## Response to Comments 1342 Congress Street - Proposed Neighborhood Center

**To:** Jean Fraser, Planner; City of Portland  
**FROM:** Greg Halsey, Tighe & Bond, Inc.  
**CC:** Steve Brinn, Jewish Community Alliance of Southern Maine  
**DATE:** May 8, 2015

**A. Reviewer: David Senus, P.E. Woodard & Curran  
Date: May 1, 2015**

CITY OF PORTLAND - VERTICAL GRANITE CURB IN EXISTING STREETS
 NOT TO SCALE

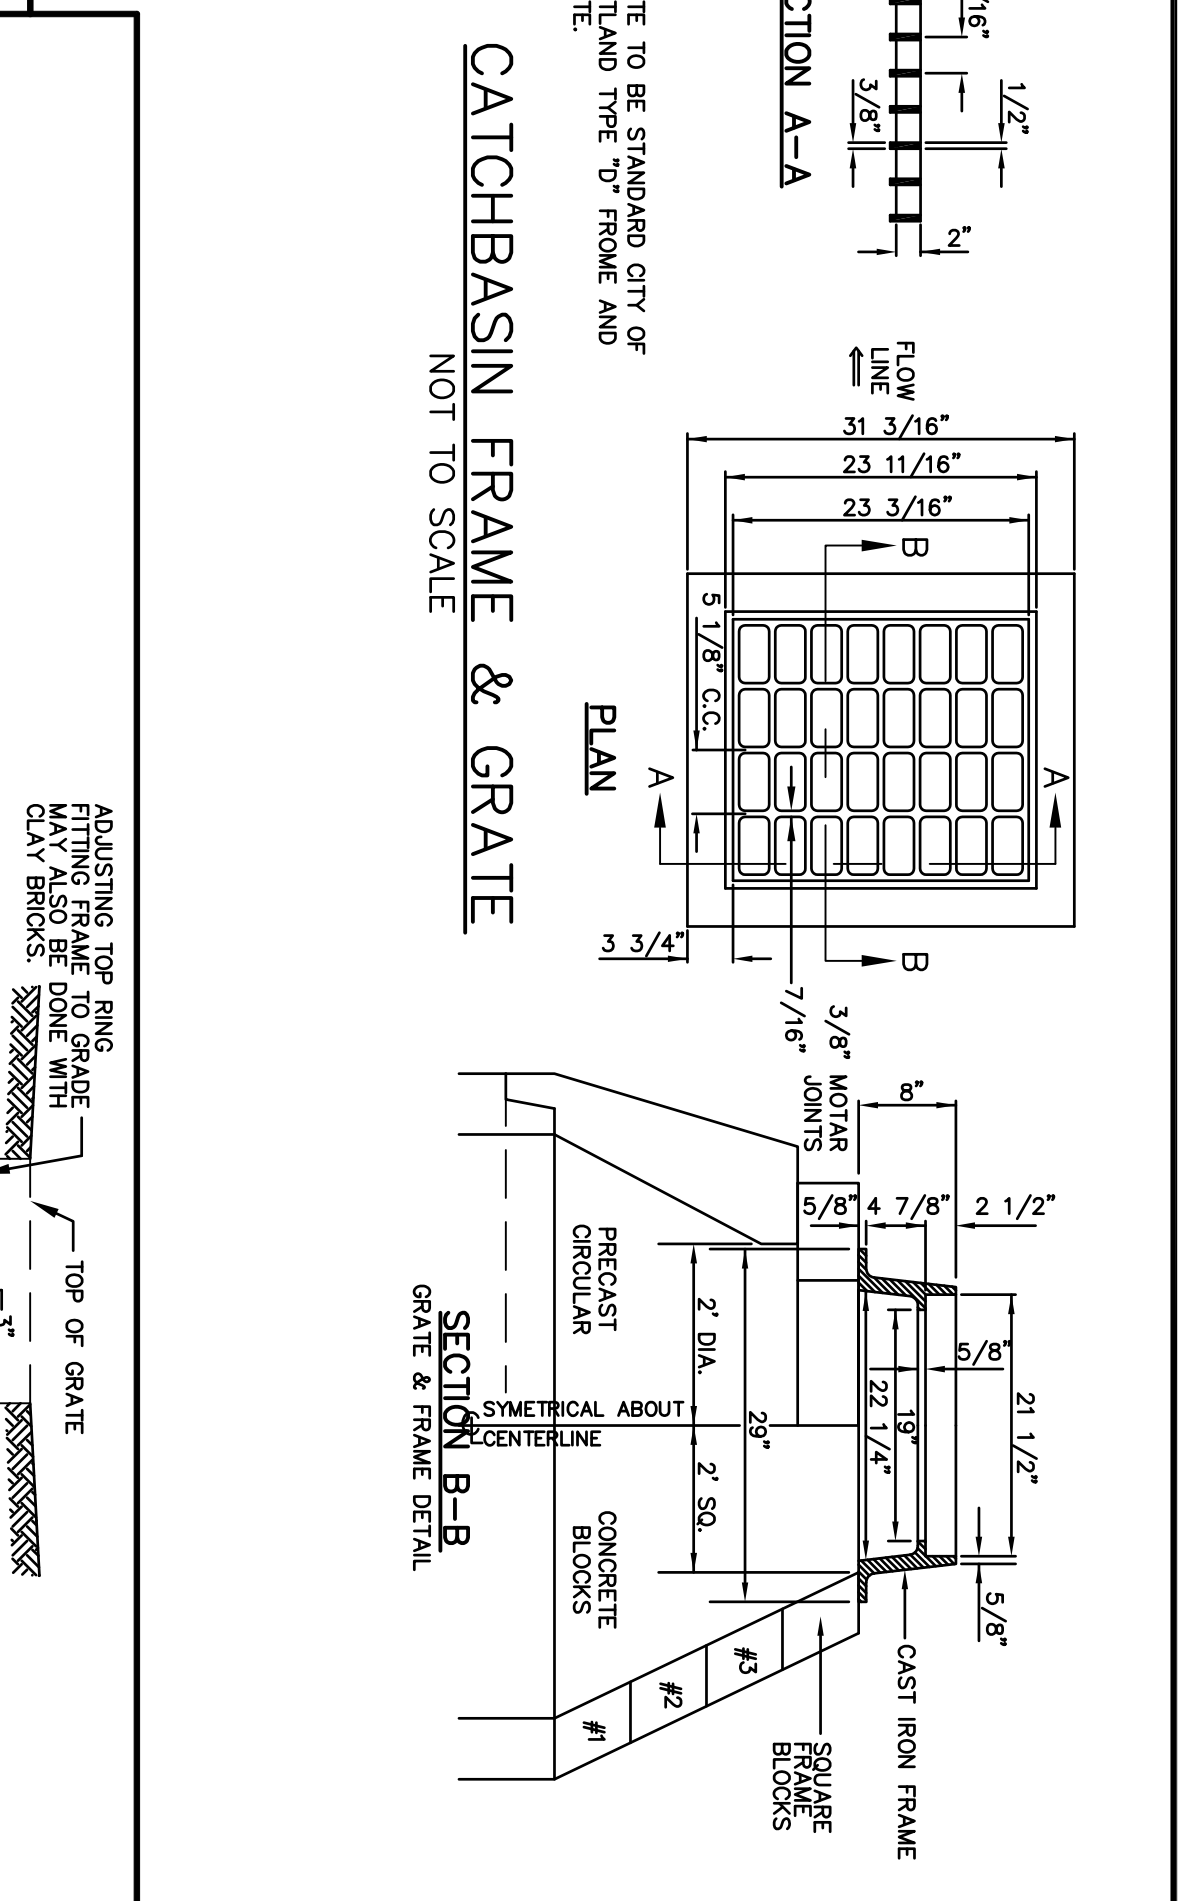
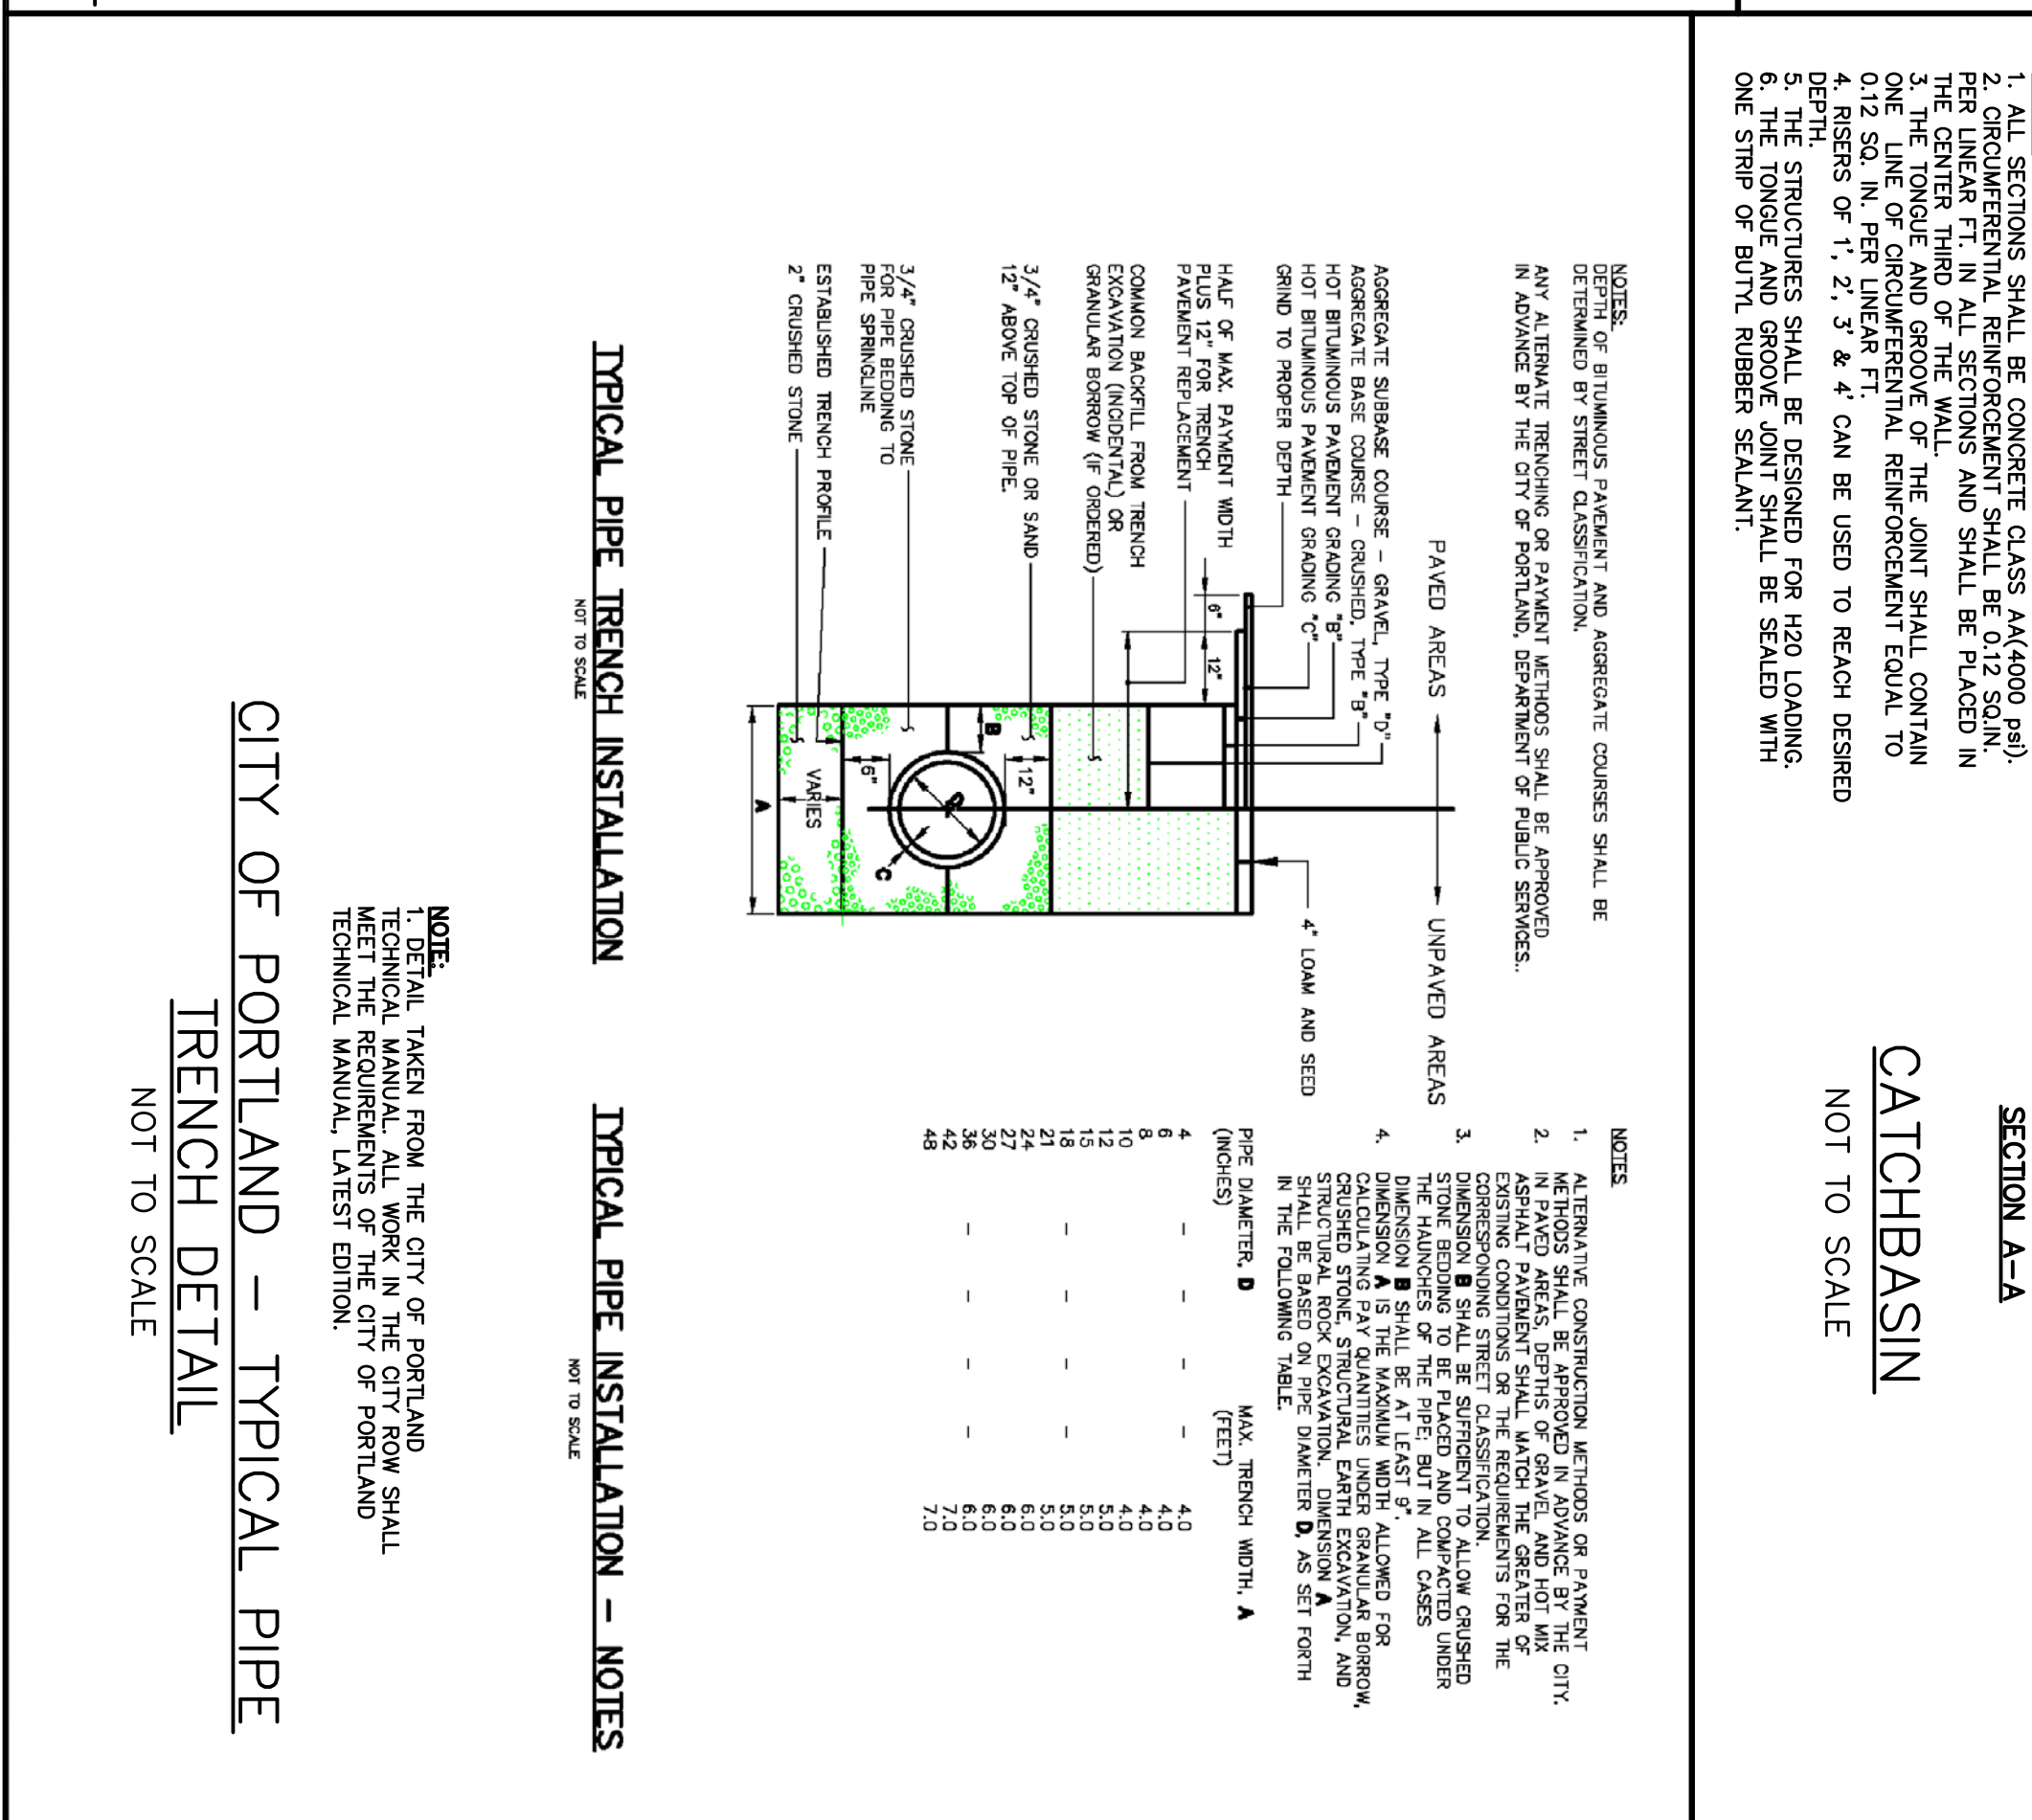
- 7) *The proposed Vertical Granite Curb, Concrete Sidewalk, and Utility Trench details should be revised to comply with the City of Portland Technical Manual for work within the City Right-of-Way.*

**Additional details for Vertical Granite Curb and a Typical Utility Trench have been provided for work within the City ROW. The concrete sidewalk detail has been revised to comply with City of Portland Technical Manual. See Sheet C-6/C-8, Details Sheet.**

C-2B

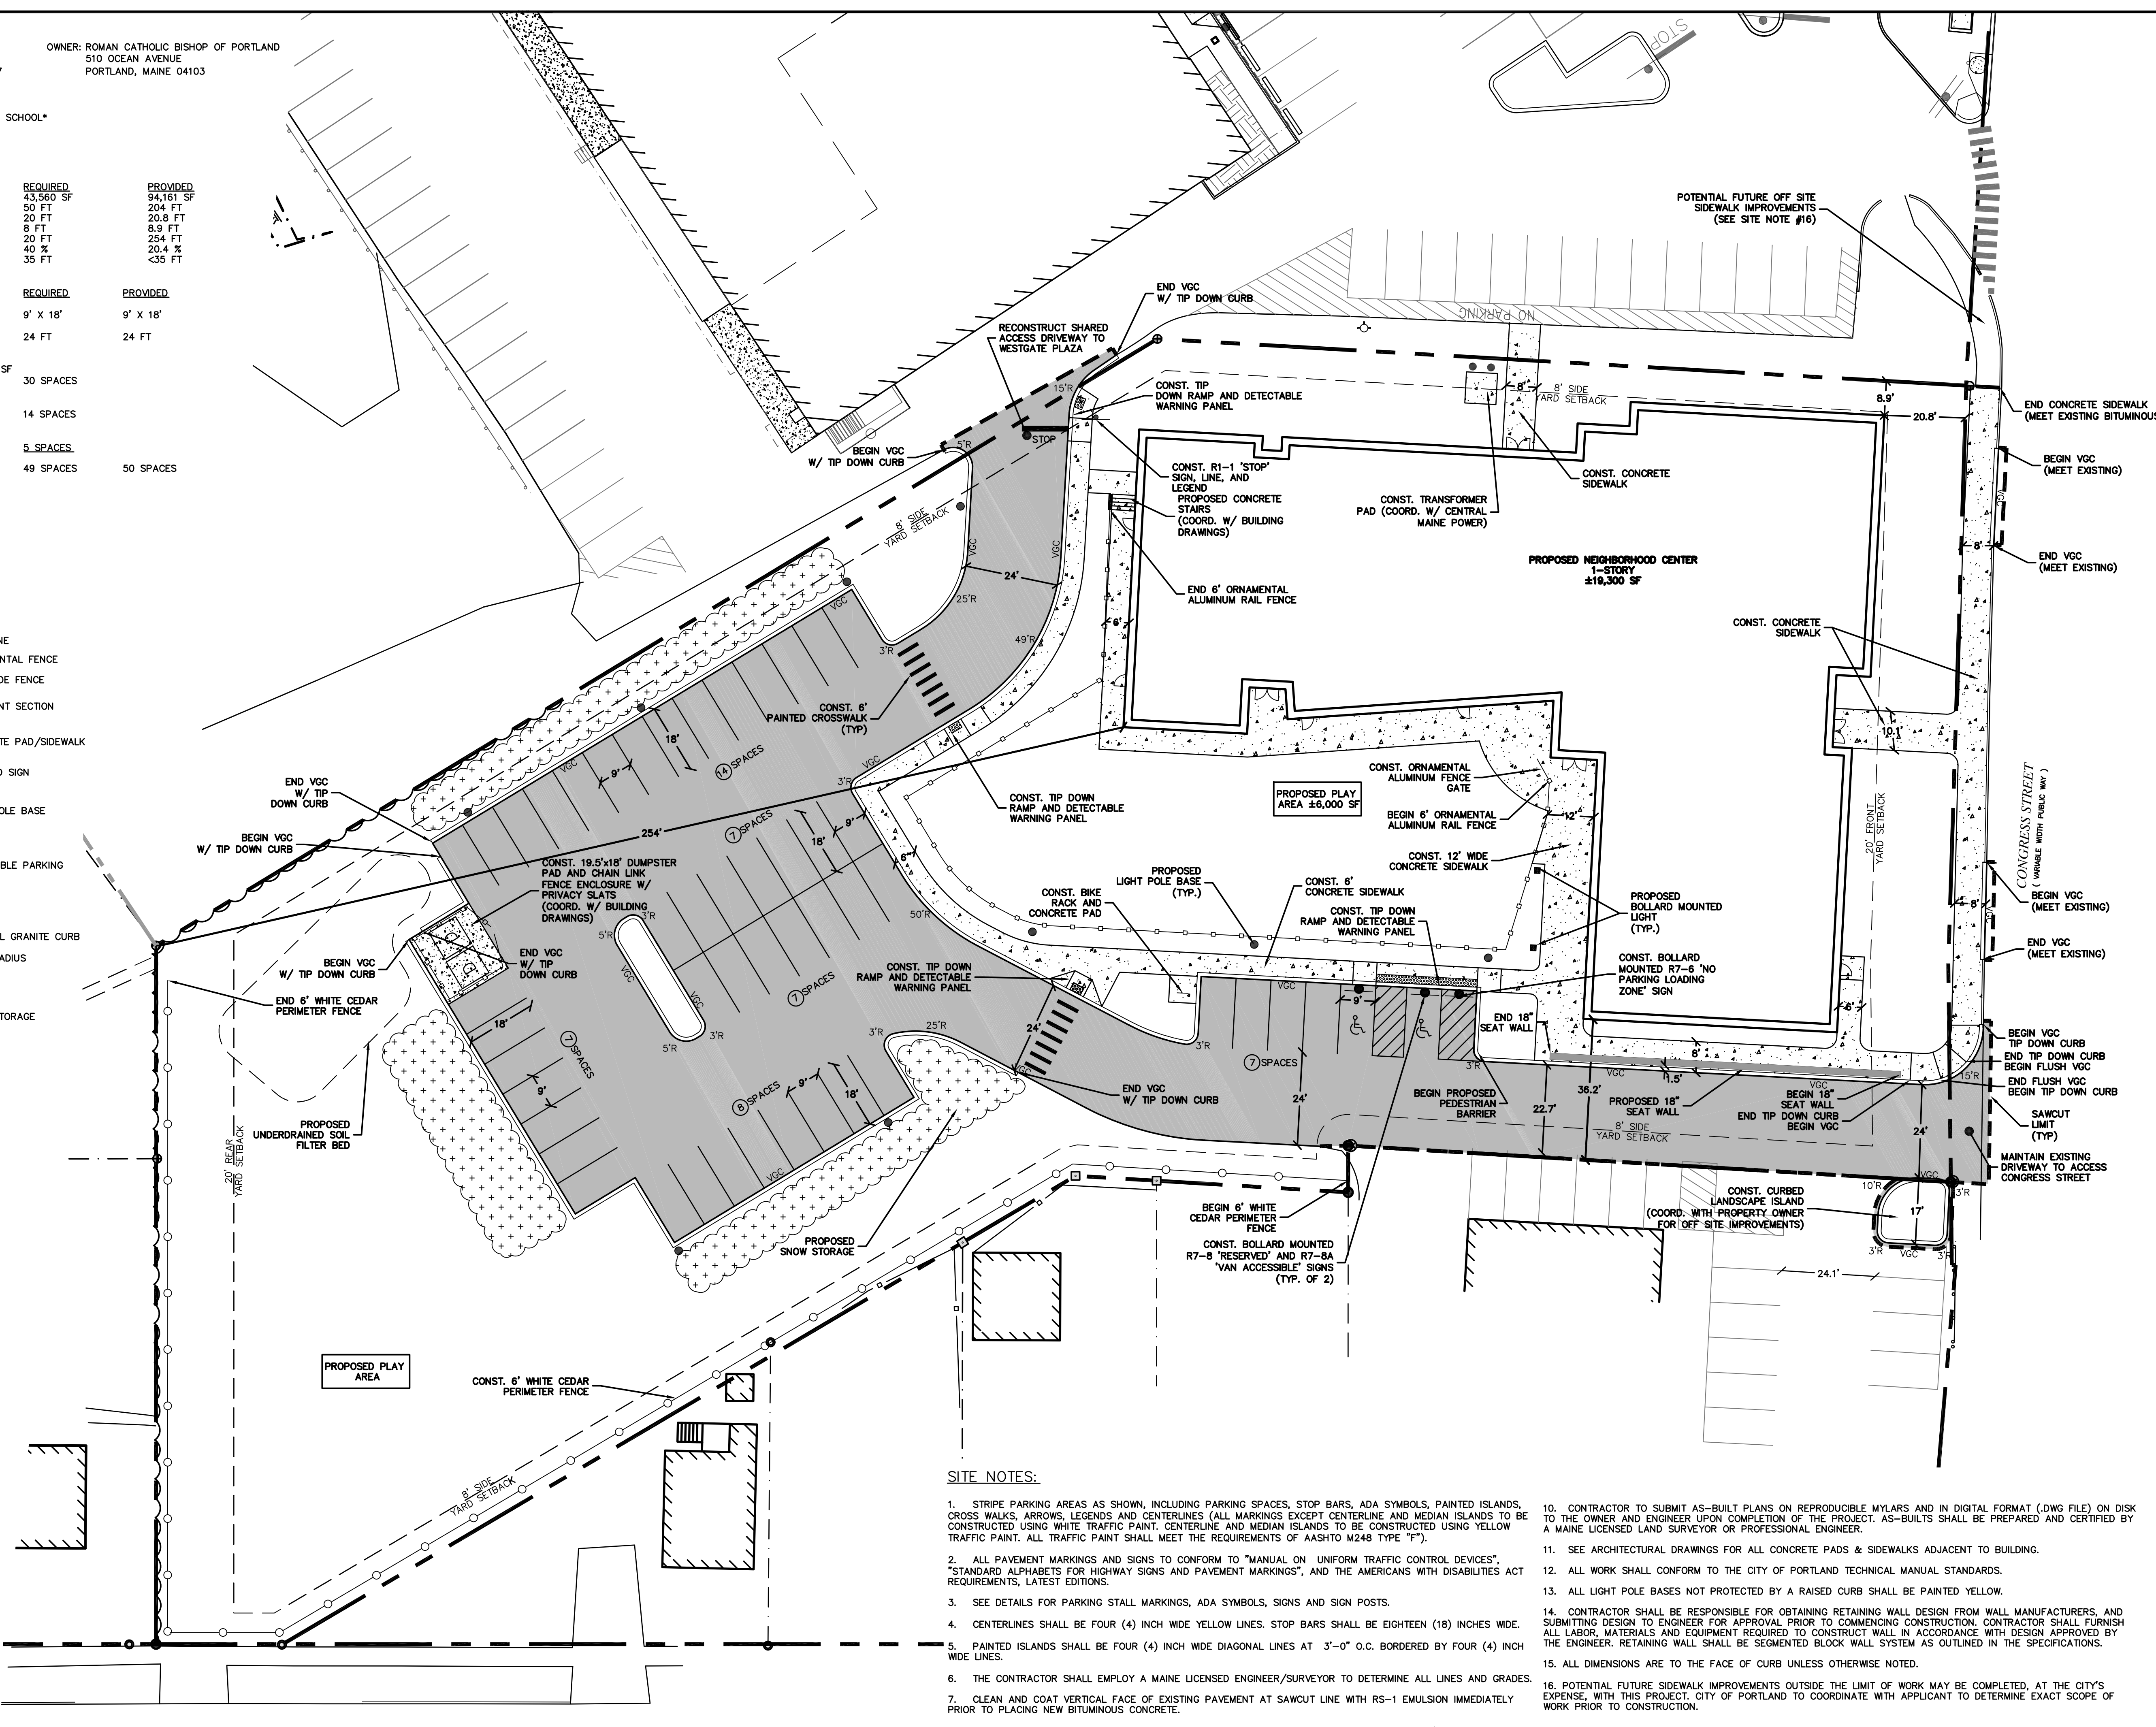
- 4) *Sheet C-2b depicts snow storage along the east edge of the rear parking lot, adjacent to several residential properties. The grading plan (C-3) indicates that runoff from this area would potentially flow onto these properties. The Applicant should limit snow storage in this area and should revisit the proposed grading to ensure that runoff from the project property is not directed onto these abutting residential lots.*

**The proposed grading in this area has been revised to provide a shallow swale that will convey runoff from snow melt or rain to the rear of the site and away from abutting properties, which is consistent with the existing drainage pattern in this area.**
